29 May 2025

Council Response to Environmental Impact Statement – SSD-19618251 for Elizabeth Enterprise Precinct – Stage 1 at 1669-1723 and 1669A Elizabeth Drive, Badgerys Creek

Figure 2 Stage 1 Concept Plan

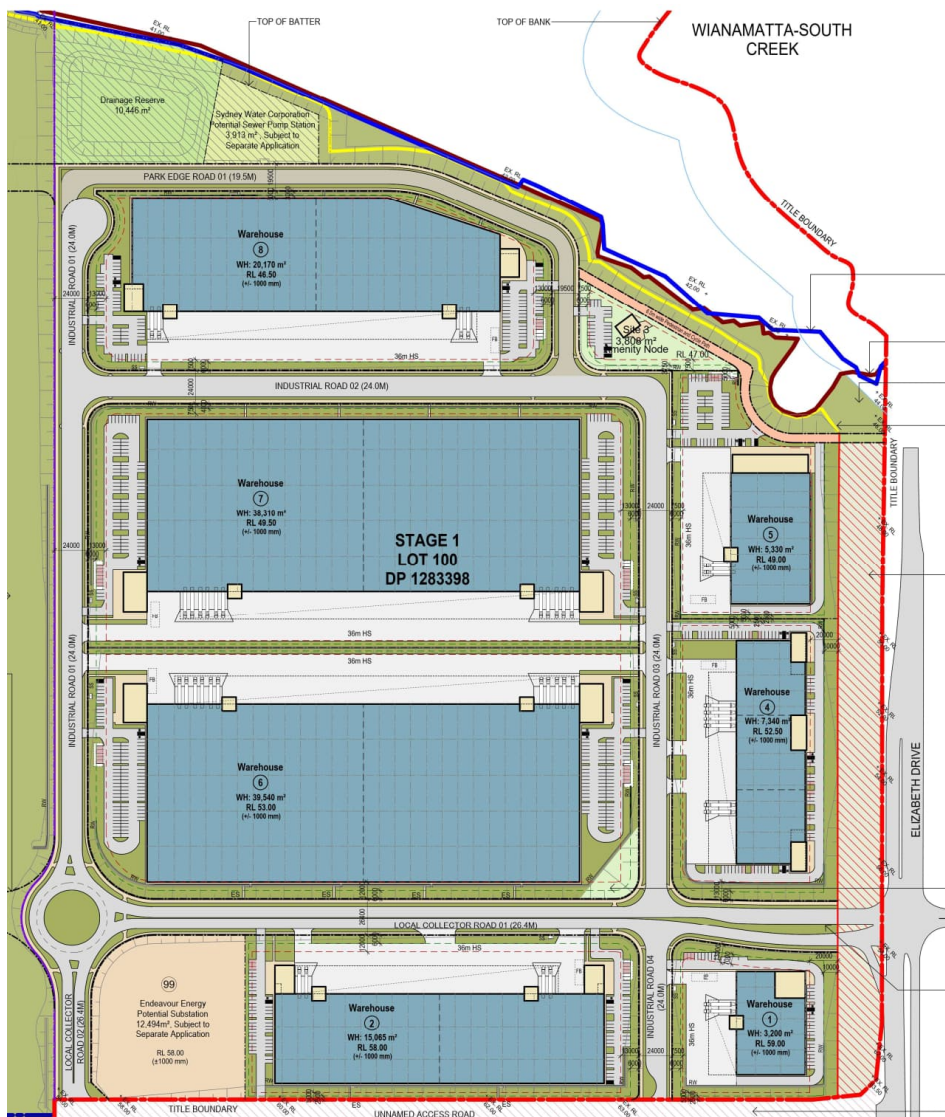
- s) Any structures to support retaining walls fronting future public roads are not permitted to encroach into the public roadway.
- t) The proposed roundabout adjoining Warehouse 8 should be delivered as a full roundabout. In both the concept drawing and the proposed subdivision plan, it appears as a half roundabout. Council would not accept a half roundabout as a future public road.

Figure 3-3: Site Plan (Warehouse 1)

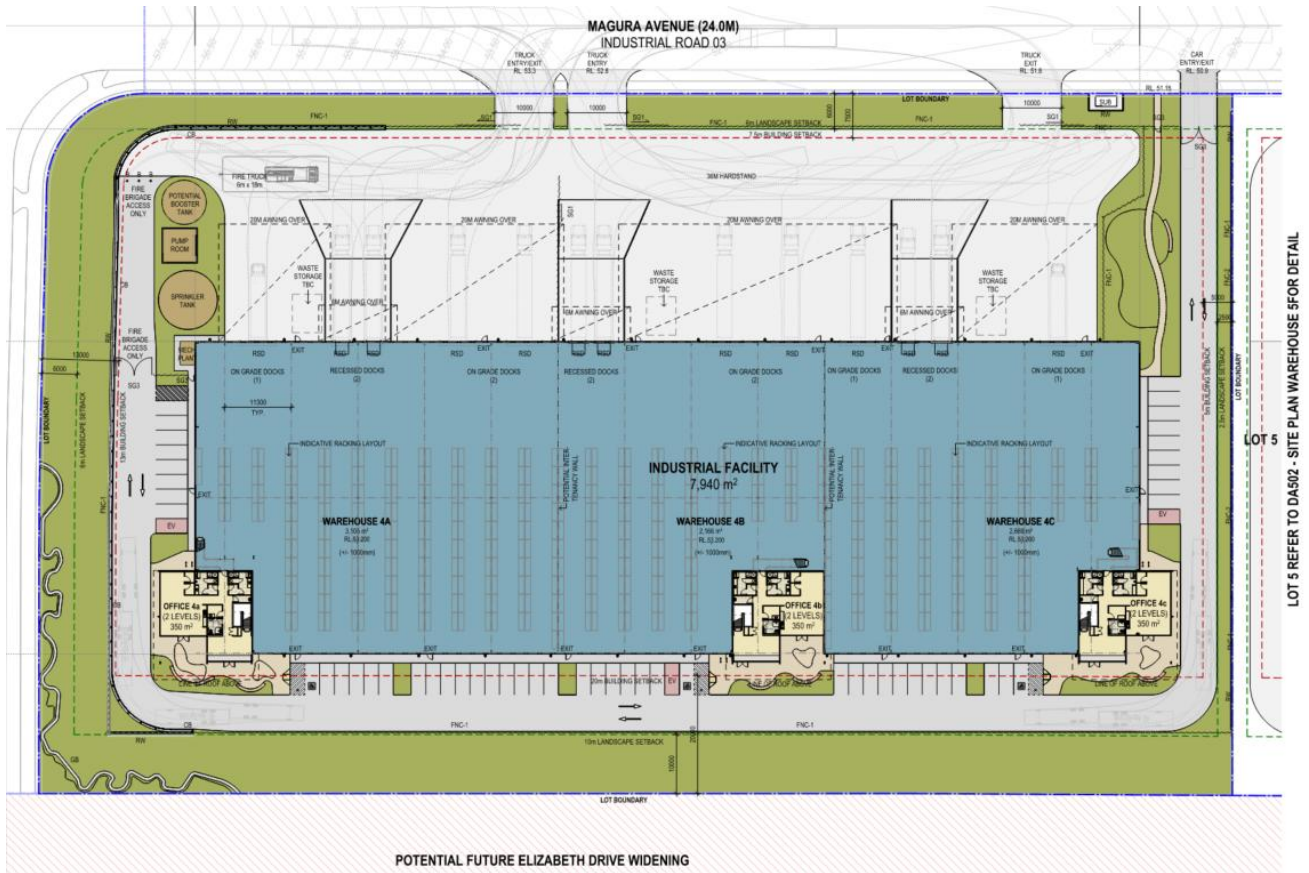
- b) For warehouse 1, mixing the carpark interface with the truck manoeuvring area is not supported. Ingress and egress for workers parking areas is to be separated from truck manoeuvring areas.
